PLANNING CONSULTATION RESPONSE

Application No	2026/0234
Proposal	Erection of side extensions; raising of roof height to create first floor accommodation; erection of outbuilding to replace existing garage and formation of 2x new vehicular accesses.
Address	1 Newfield Avenue, Monk Bretton, Barnsley, S71 2LD
Date of Consultation Reply	20 th April 2026
Consultee	Highways DC

1 NEWFIELD AVE.
MONK BRETTON
BARNSELY S71 2LD
LOCATION & SITE PLAN 1:1250, 1:500@A4

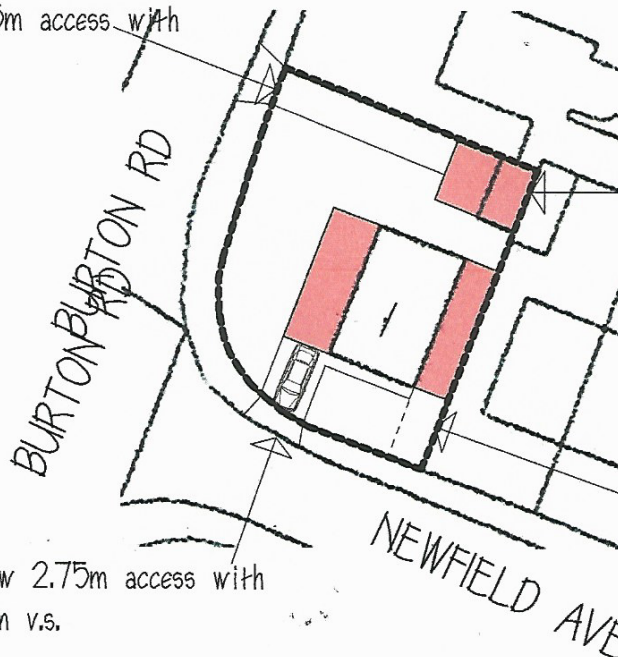
The site is currently served by a single vehicular access off Newfield Avenue which leads to a long driveway and detached garage thereby providing the site with ample off-street parking. The proposed side extensions to the dwelling would result in the removal of the existing access and the creation of two new vehicular accesses – one off Newfield Avenue and the other off Burton Road.

The proposed access off Newfield Avenue is positioned too close to the priority junction with Burton Road (approx. 11m); a vehicular access must be positioned a minimum distance of 20m from the junction as per the existing access. Additionally, the driveway is of insufficient length, the minimum forecourt depth (the length of driveway for a parking space in front of a garage) is 6m for garages with an up and over door and 5.5m for garages with a roller shutter door.

With regard to the proposed access off Burton Road, the driveway would need to be slightly repositioned approx. 0.5m to the south to avoid access/egress being impeded by the lighting column. Also, given that Burton Road is classified (C435) there is a requirement for internal turning facilities to be provided so that vehicles can enter and exit in a forward gear in the interests of highway safety. Classified roads by their very nature are busier roads and it is considered that vehicles reversing to/from the driveway would have a detrimental impact on highway safety for oncoming vehicles on Burton Road.
